**Alan Allison**  
Woodland  
West Walberton Lane,  
Walberton,  
Arundel,  
West Sussex BN18 0QS

14 December 2019

Your Ref WA/7/19/RES

**email 25 November 2019 on Minor Amendments sent to Parish Council**

PJ DEVELOPMENTS LTD 2 Square Chambers 23 High Street Emsworth PO10 7AQ Tel: 0843 289 3430 Email: enquiries@pjdevelopmentsltd.com	
PROJECT: FORMER LANES END	
SITE PLAN OUTLINE PLANNING APPLICATION	
DATE: JANUARY 2019	DWG. NO 19-001 PL02
SCALE @ A1: 1:200	
REV: C

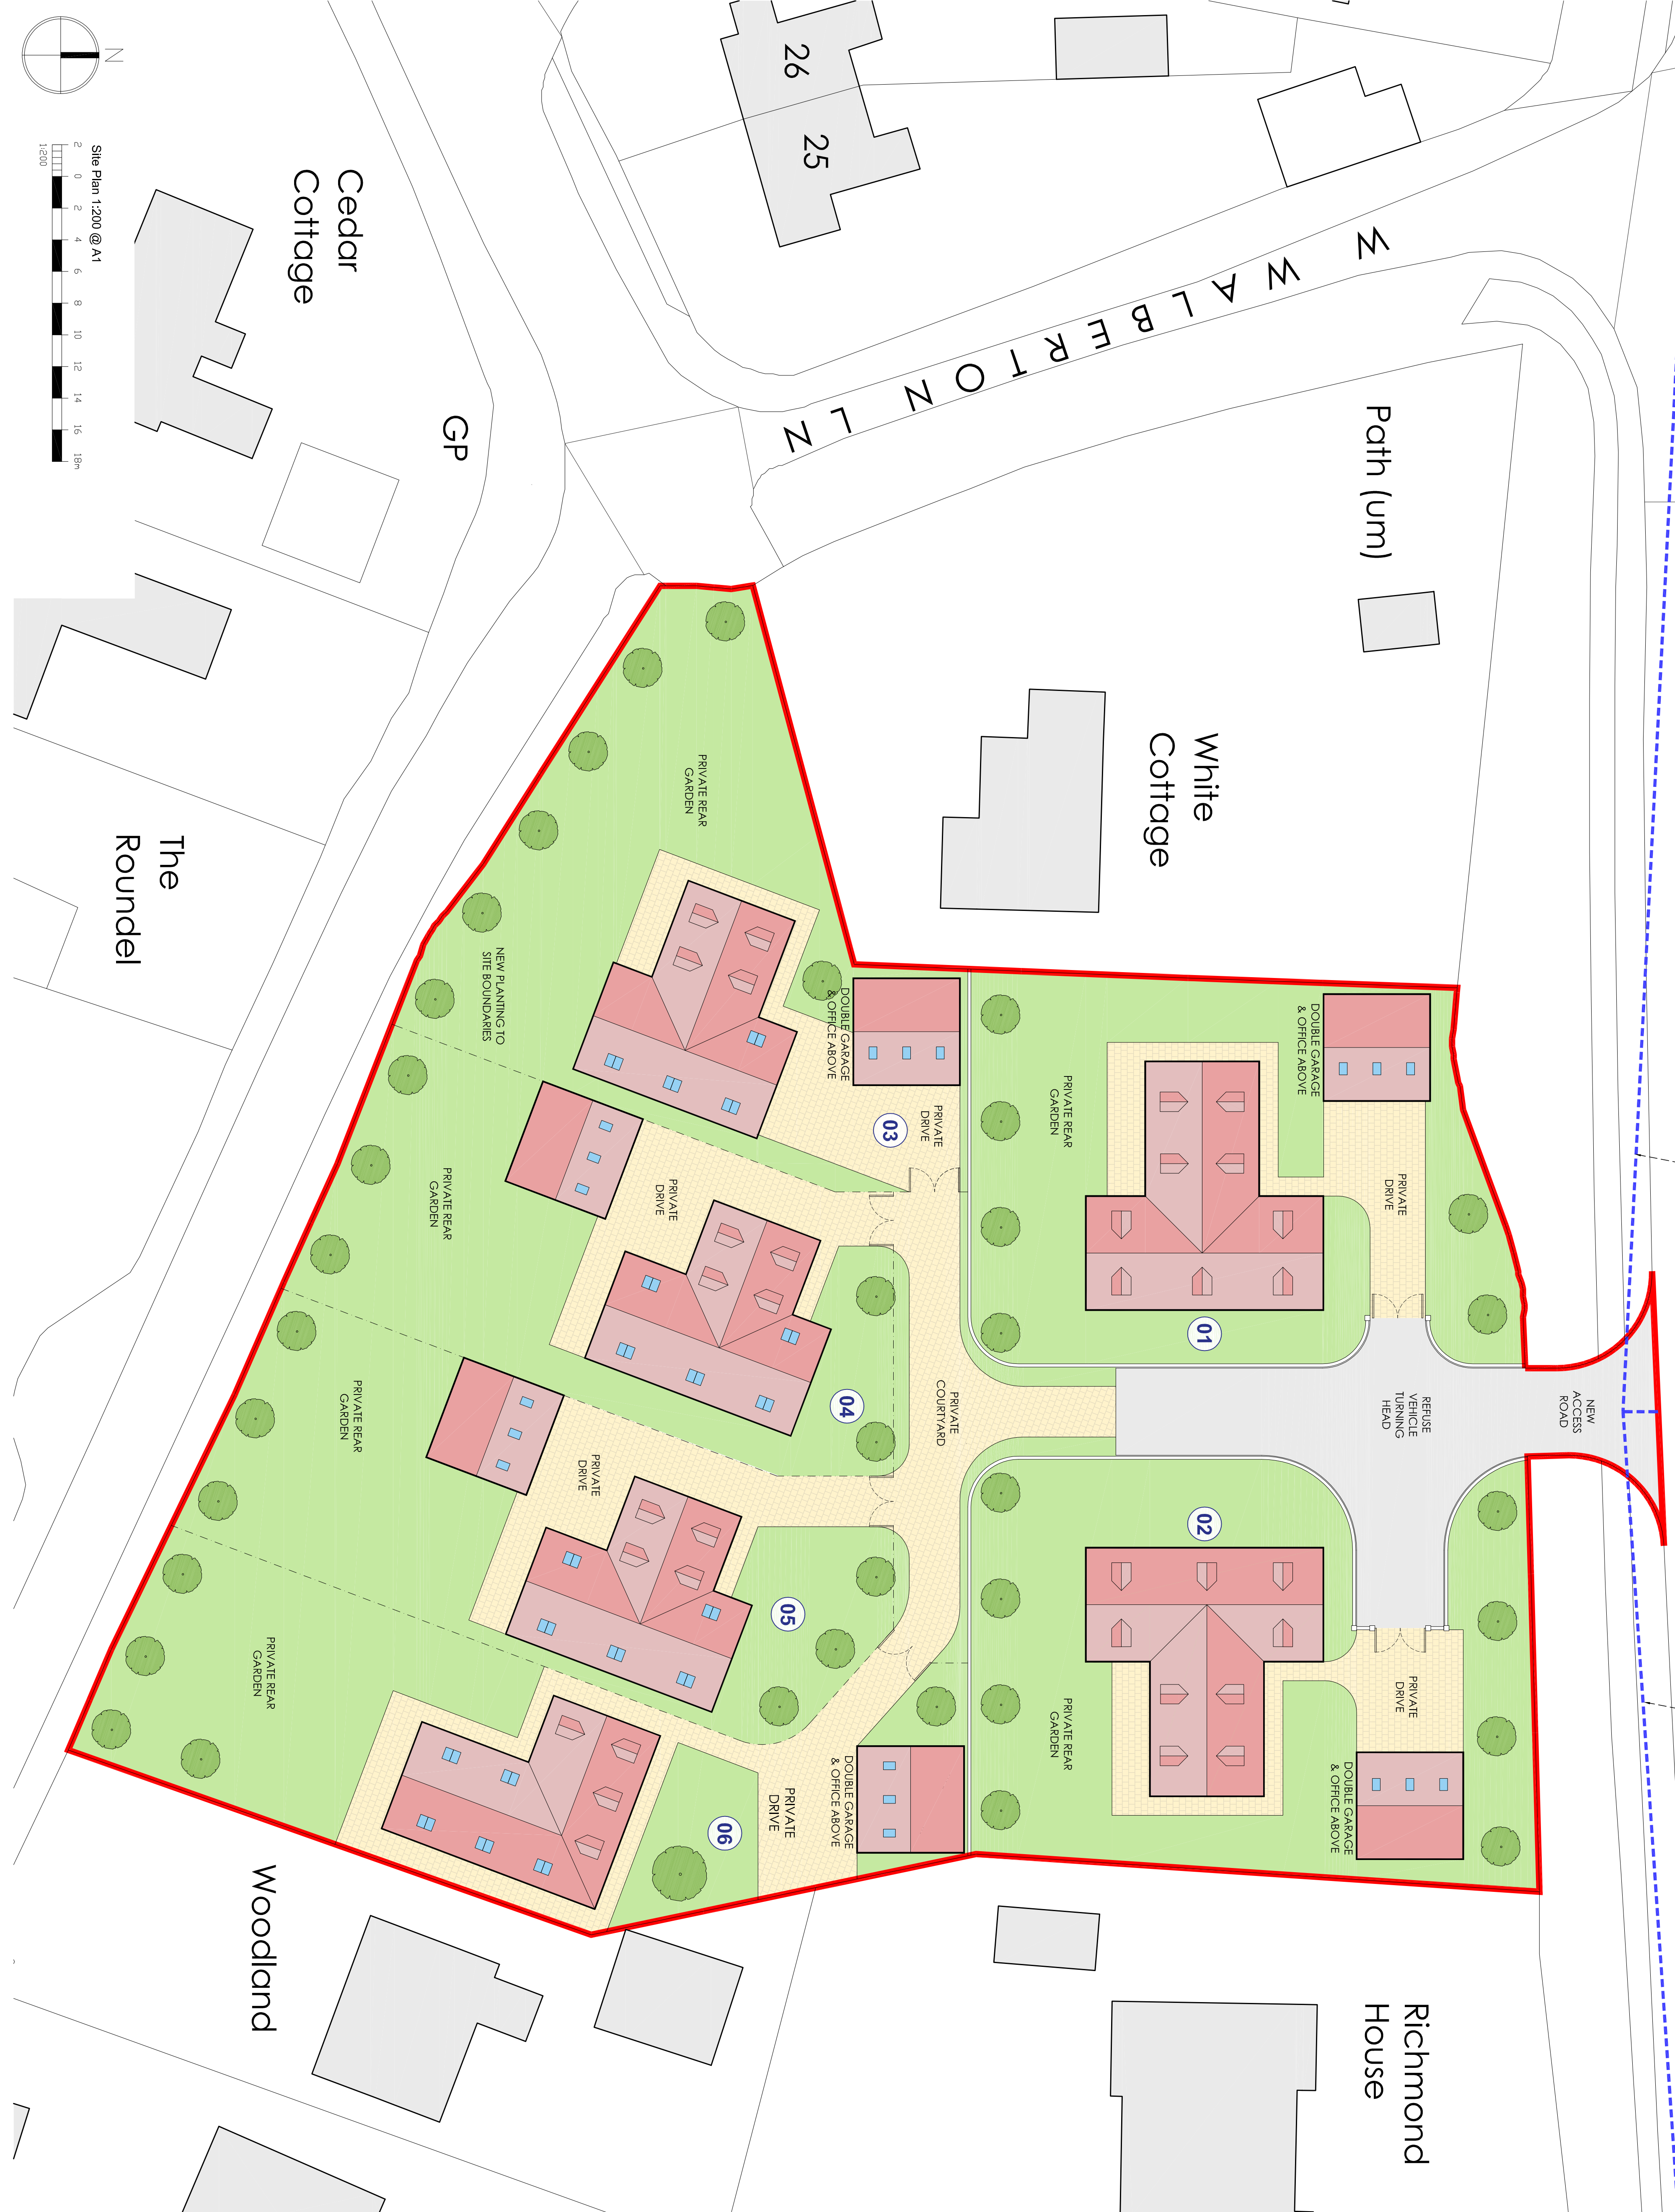
With regard to the above was the Parish Council the only consultee that was informed of Option Unit 6? The new location was moved further south than originally shown and would have an effect on both highway services and trees. Such matters I believe were addressed in my Comments of 2 December 2019.
